Meeting note

File reference EN010082
Project Tees CCPP
Status Final

Meeting with Sembcorp Utilities (UK) Limited

Tees CCPP: Comments on the draft Habitats Regulations Statement - No Significant Effects Report (NSER)

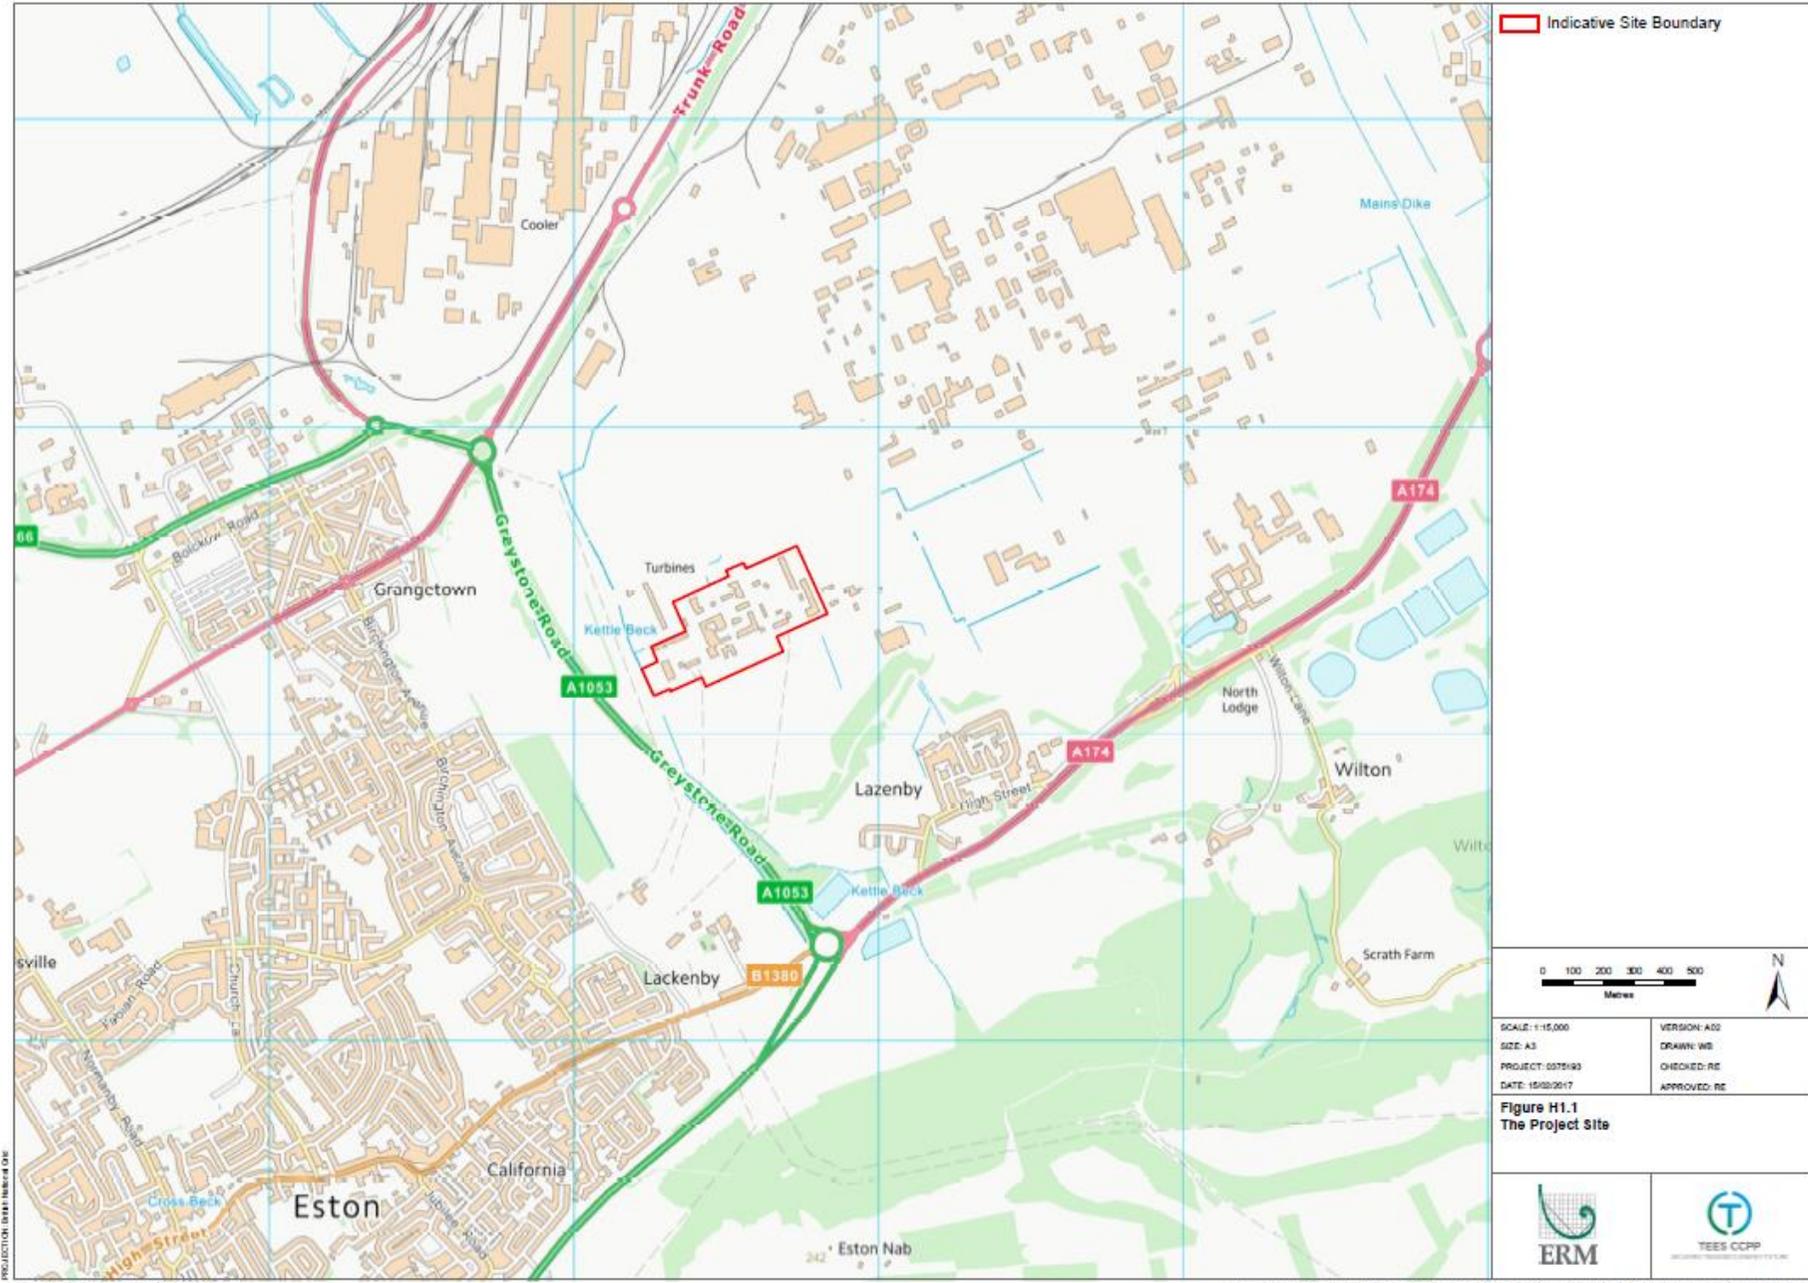
Point no.	NSER reference	Extract from NSER	Question/Comment
1	Section H1 (Introduction)	n/a	The NSER should provide a brief description of the site and surrounding area. This could be supported by a figure illustrating the red line boundary of the Proposed Development (at a smaller scale than Figure H.1).
2	Section H2.6 (Consultation and Key Issues)	Consultation with Natural England	 The Applicant should seek to agree a Statement of Common Ground (SoCG) with Natural England and submit this with the DCO application. In respect to the NSER, the SoCG should confirm agreement on: The 15km study area; The European sites scoped into the screening assessment; The scope of impacts considered in the screening assessment; The conclusions of the screening assessment – ie. that there would be no LSE, either alone or in combination, on any of the European sites screened into the assessment; and That an appropriate assessment is not required. Providing evidence of agreement on these issues with the DCO application may reduce the need for the Examining Authority to ask questions in this regard.
